**Crown Sydney Hotel Resort, Barangaroo South - SSD 6957 MOD 1**

Thank you for your correspondence, dated 12 June 2019 inviting the City of Sydney to respond to the proposed modification of SSD 6957 relating to the Crown Sydney Hotel Resort (CSHR) at Barangaroo South.

Scale @ A1: 1 : 200	Drawing and CAD File Number: 00915 - S - 2003 - TP
------------------------	---

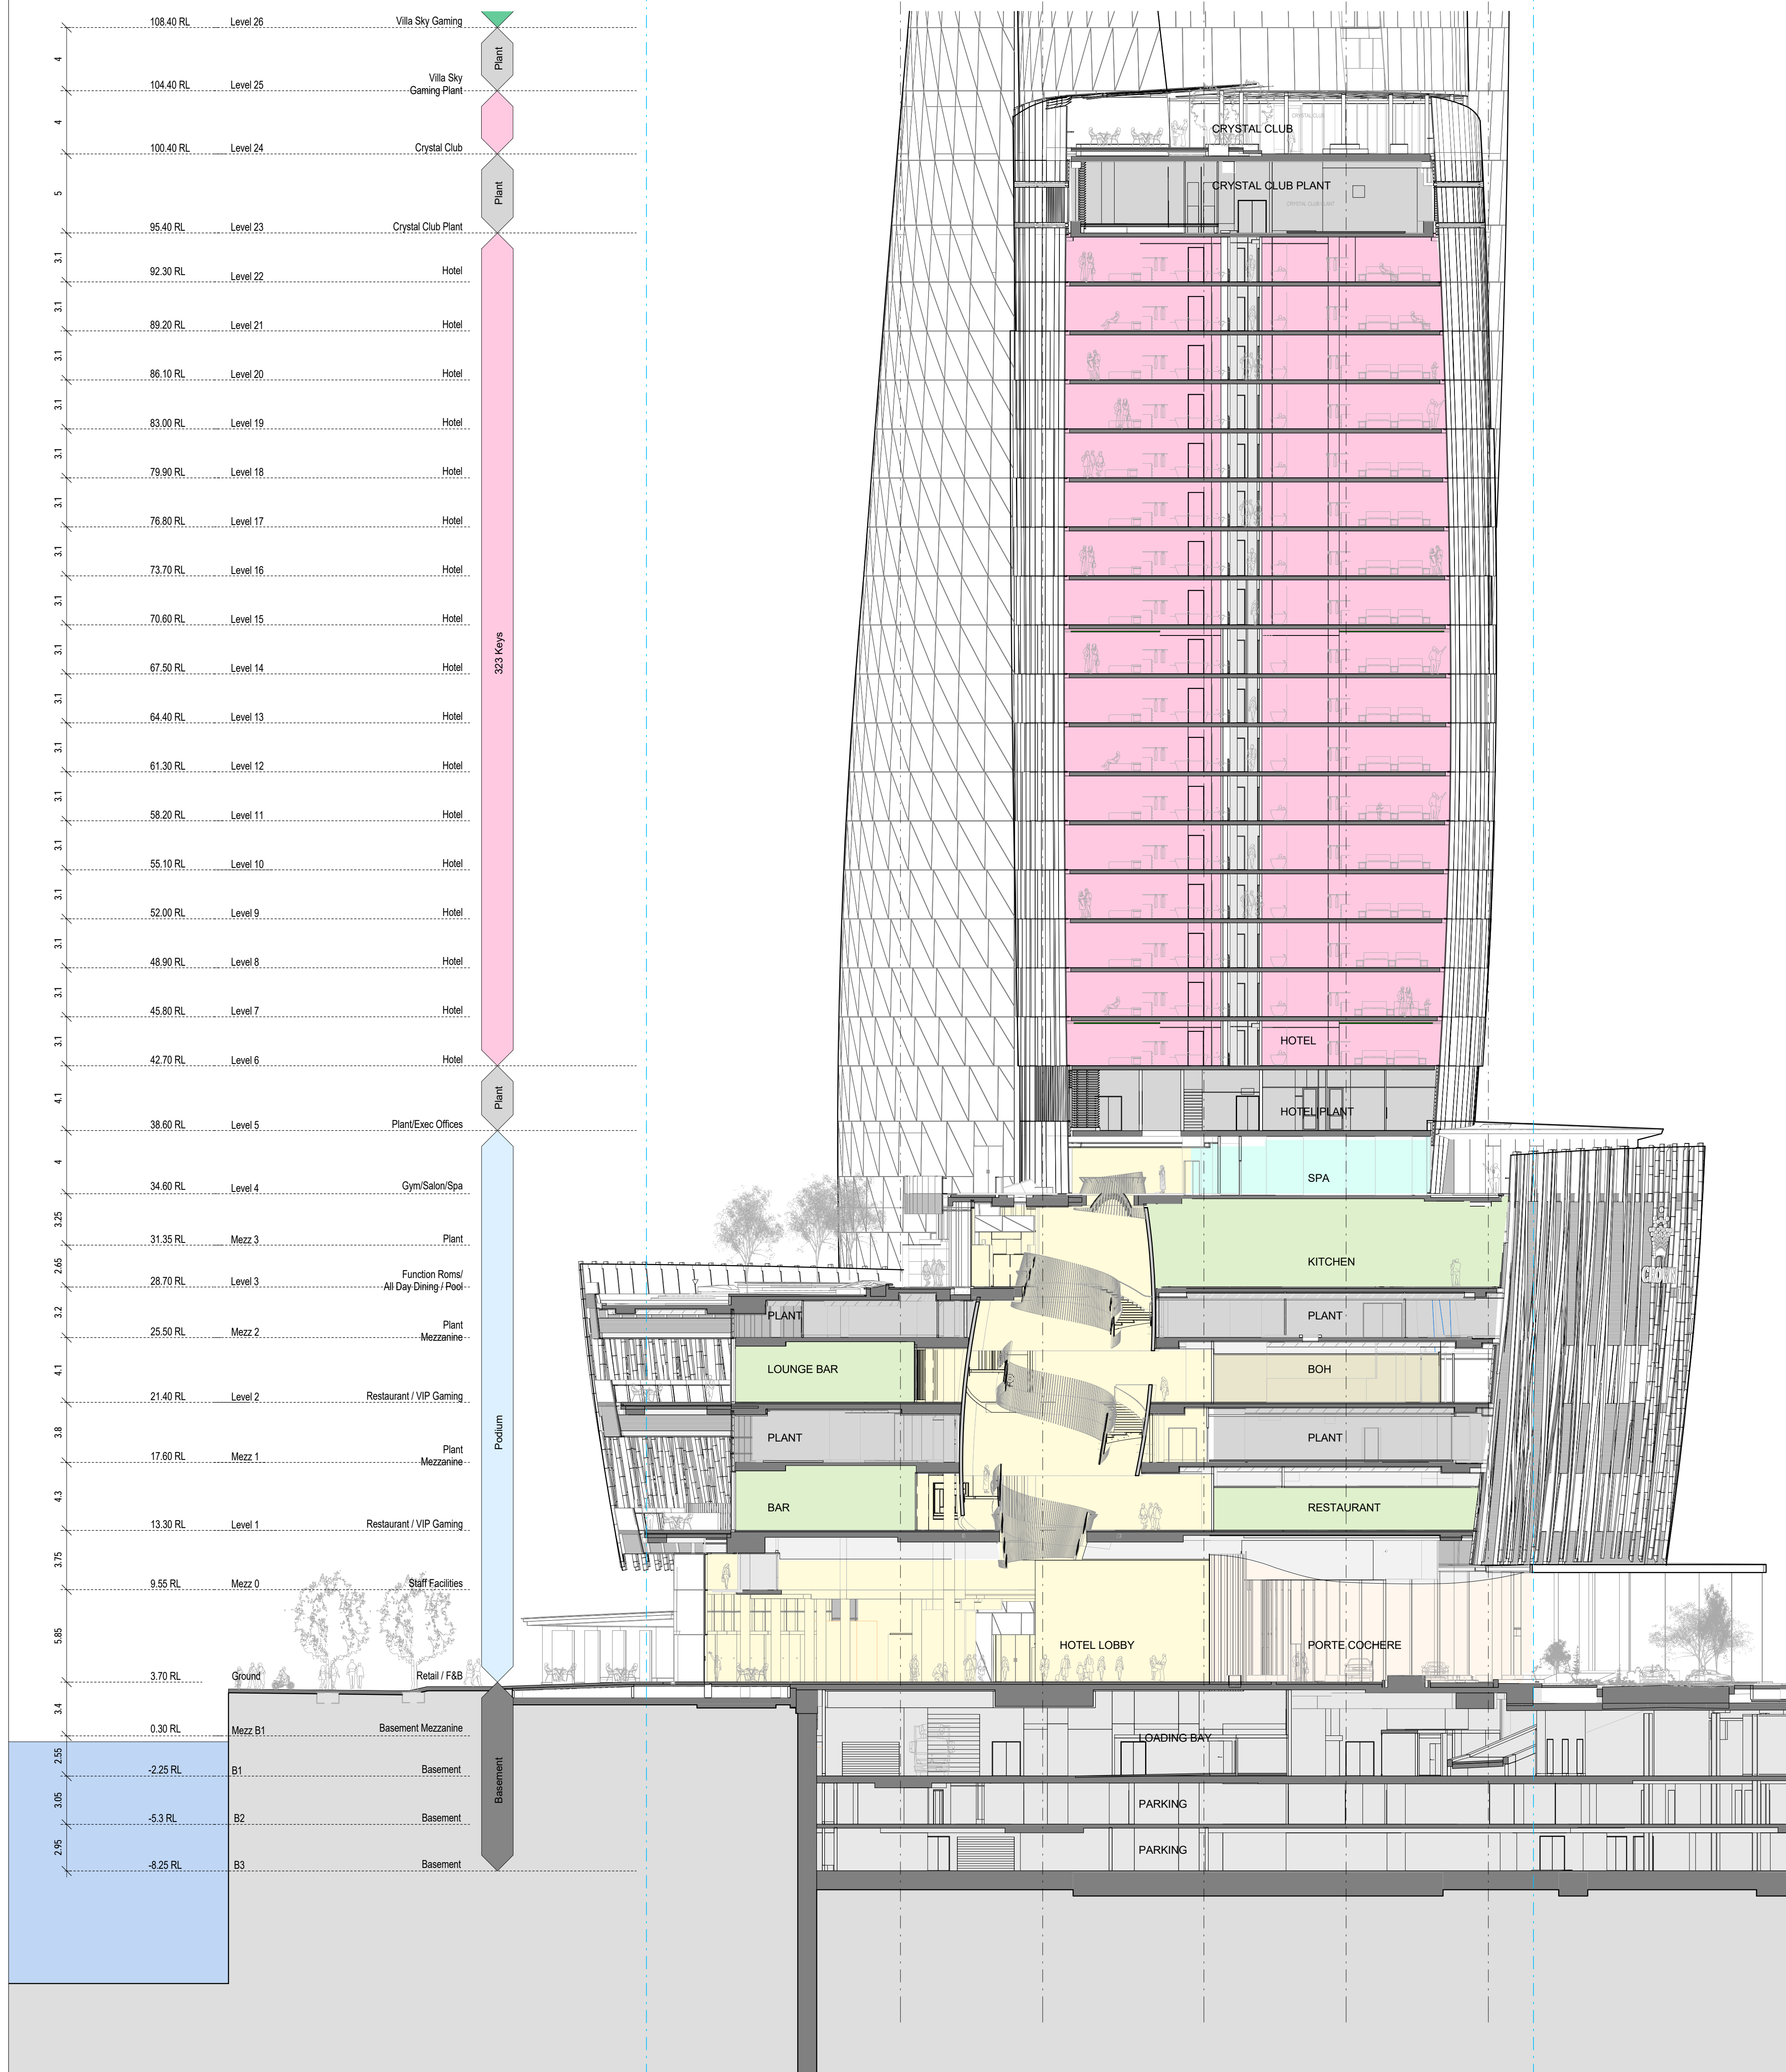
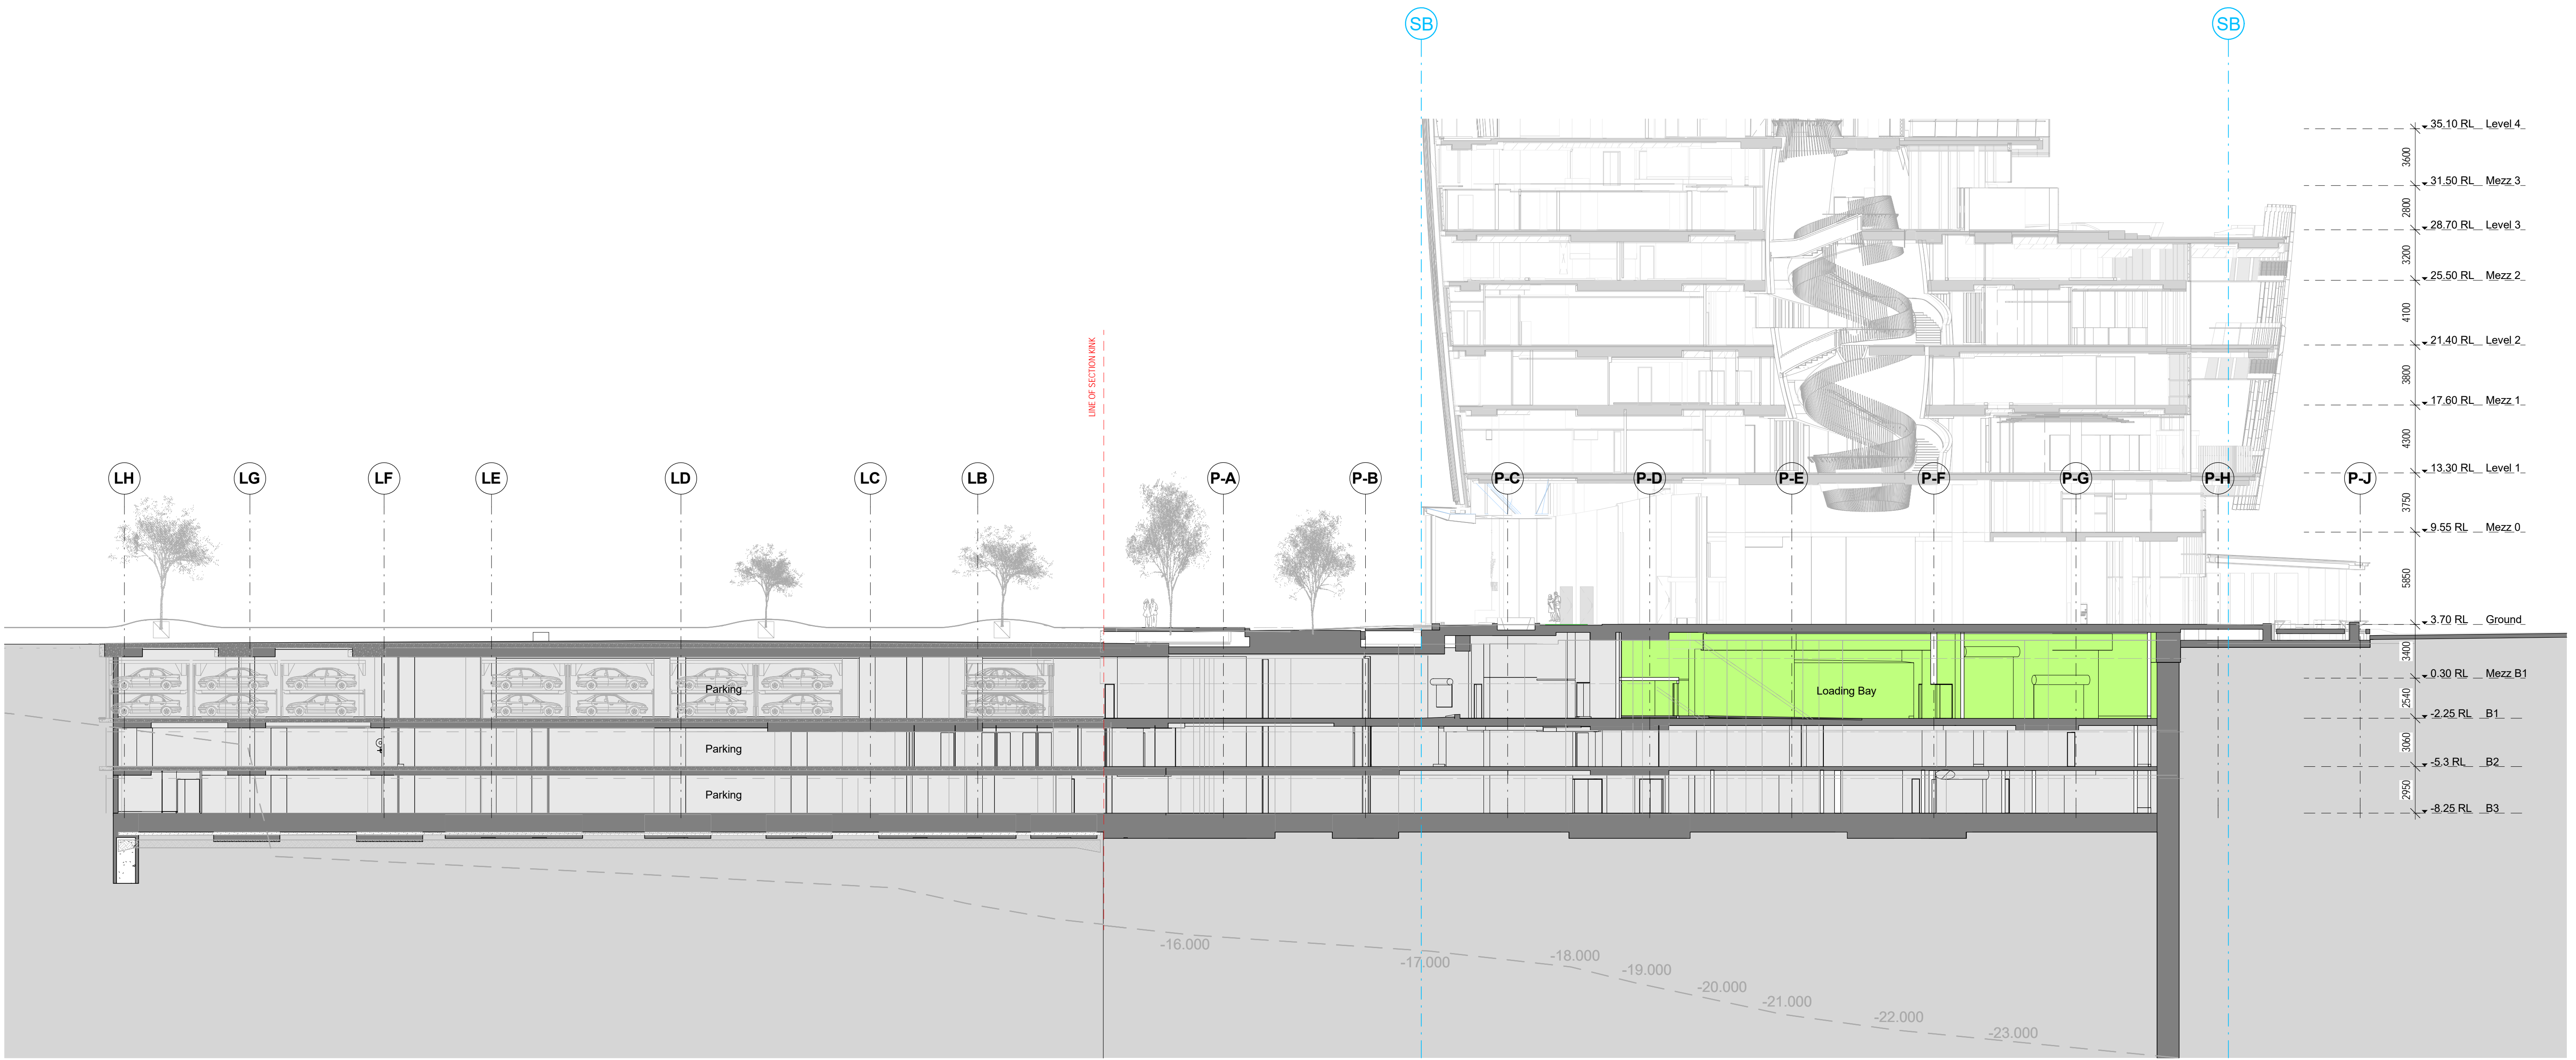
The enclosure and further privatisation of an outdoor terrace as shown in Figures 1 and 2 below encroaches on the suggested 25m setback of the building at the ground floor and reduces the width of the open space from the water's edge to only 16.7m. The introduction of 3m high wind blades at the north-western bar terrace proves to enclose an approved outdoor space with little improvement to outdoor pedestrian comfort within the public domain, failing to adequately address wind impacts of the development on the already reduced public promenade.

**Figure 2** Proposed wind breakers in outdoor bar terrace (excerpt from drawing number 00915-S-2003-TP Section CC Hotel prepared by Wilkinson Eyre)

Drawing and CAD File Number:
00915 - P - 0103 - TP

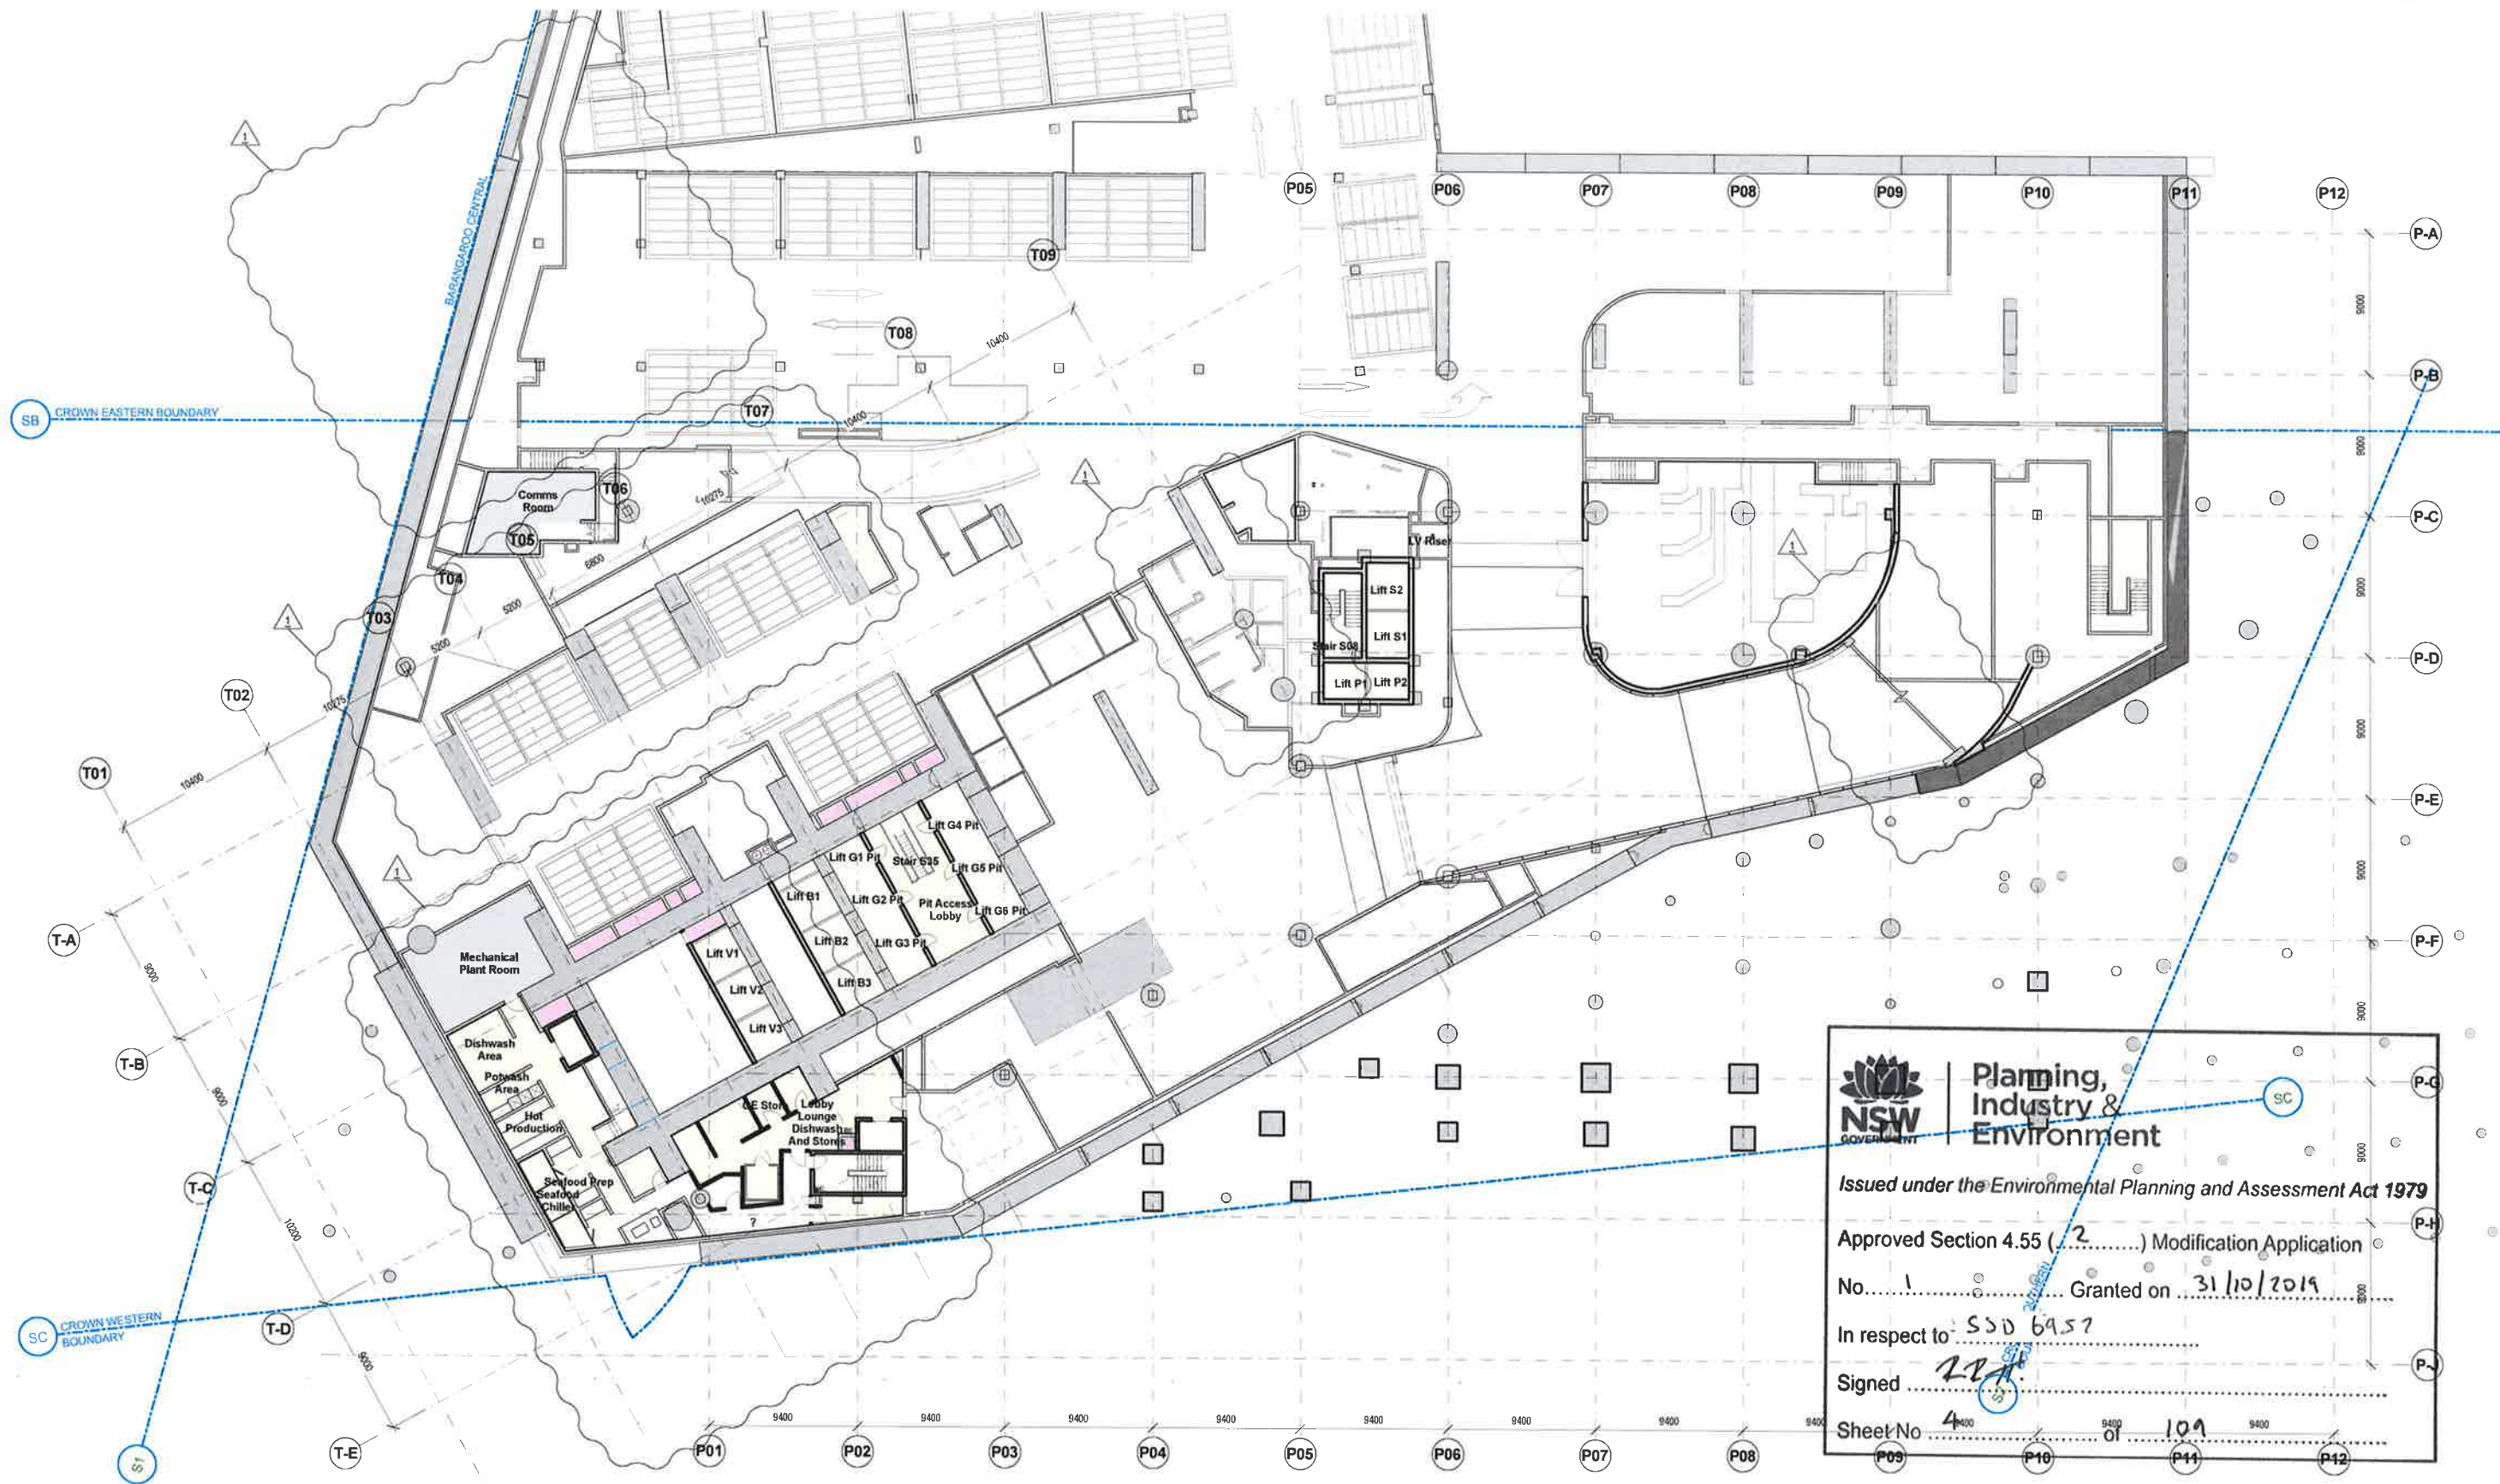
The proposed wind mitigation efforts on the ground floor are considered to have a detrimental impact on the public domain with the introduction of full height blades to the outdoor bar terrace.

**Figure 1** Building setbacks from the water's edge and location of proposed wind breaks in red (excerpt from drawing number 00915-P-0103-TP *Site Plan – Ground floor* prepared by Wilkinson Eyre)
